Please ask for: Ms Iqraa Malik
Email: iqraa.malik@terraquest.co.uk
Telephone: 0121 234 1390
Our Ref: R/168/24/PL
Your Ref:
Date: 16th September 2024

Application for Planning Permission

Development: Install patio doors to enclose the current open balcony area.
Location: Climping Court, Flat 12 Rackham Road Rustington BN16 2LQ

Drawing Existing Location & Site Plan

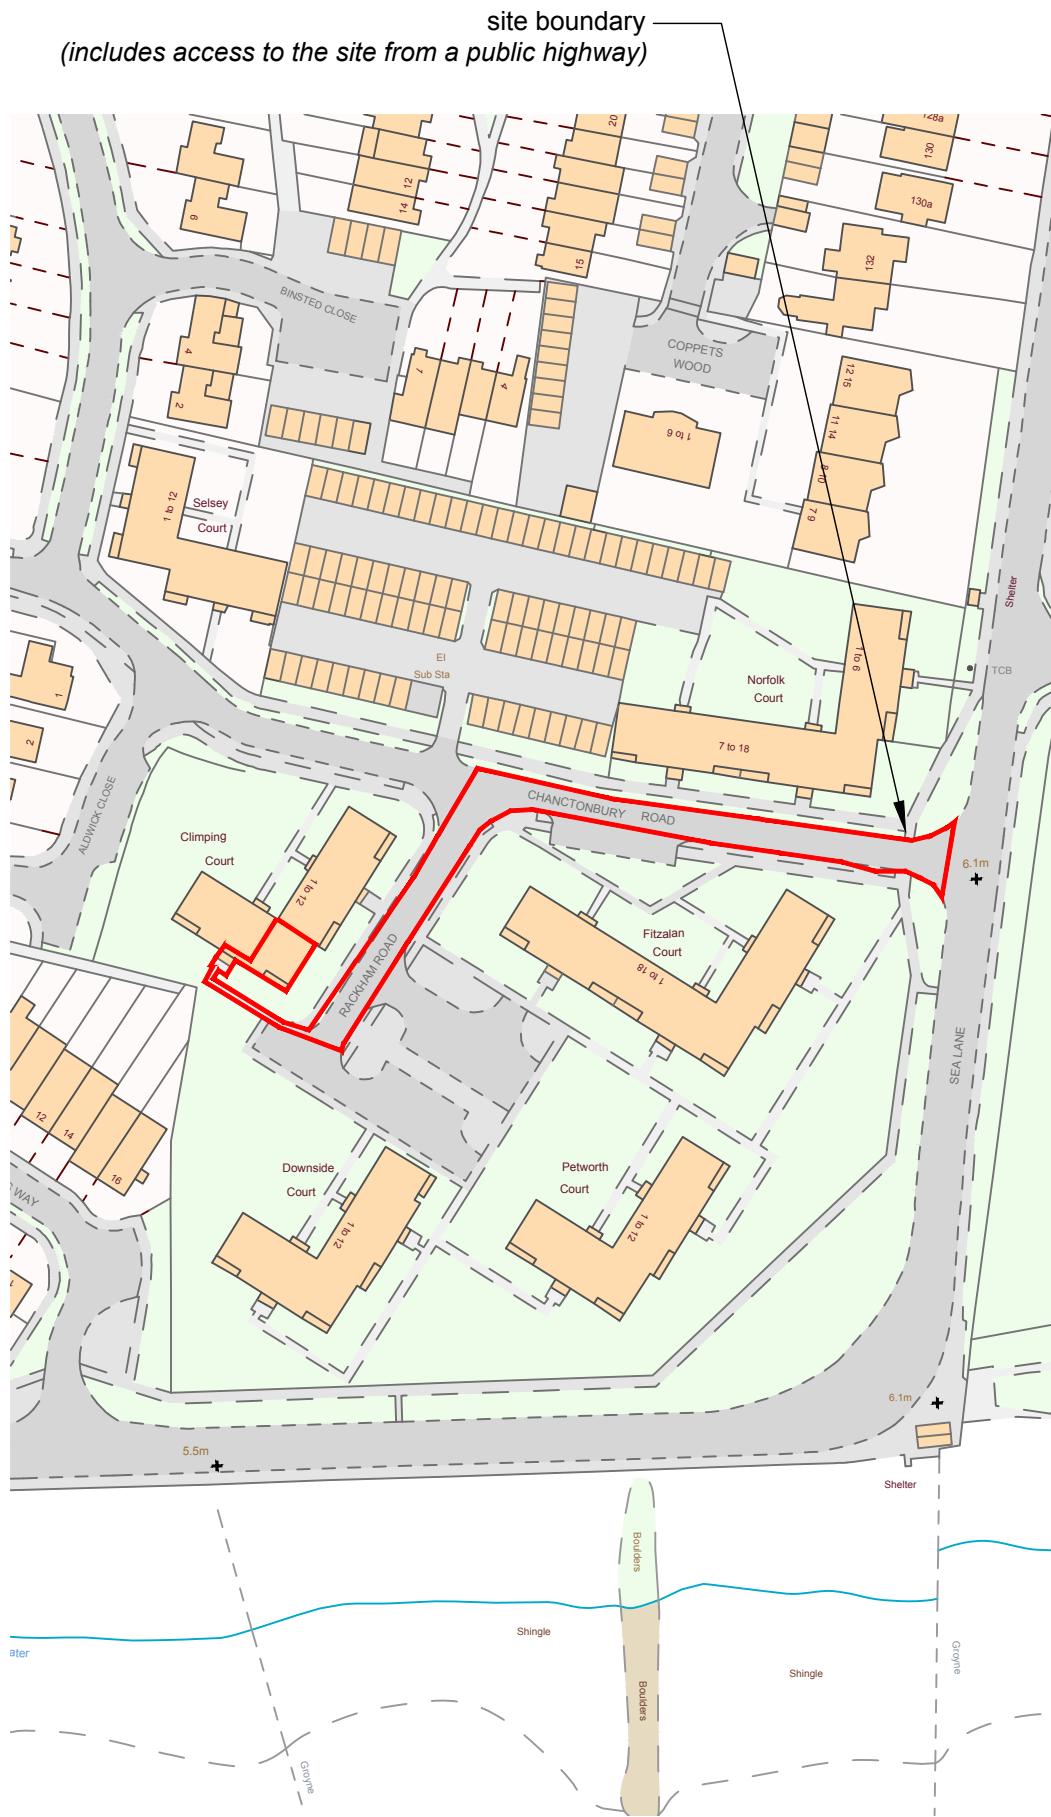
Location Plan Insufficient

The location plan requires a solid red outline around the site boundary, the outline must also include access to the site from a public highway, please review and amend. Further details of what must be included on the plan can be found in the Validation Requirements List.
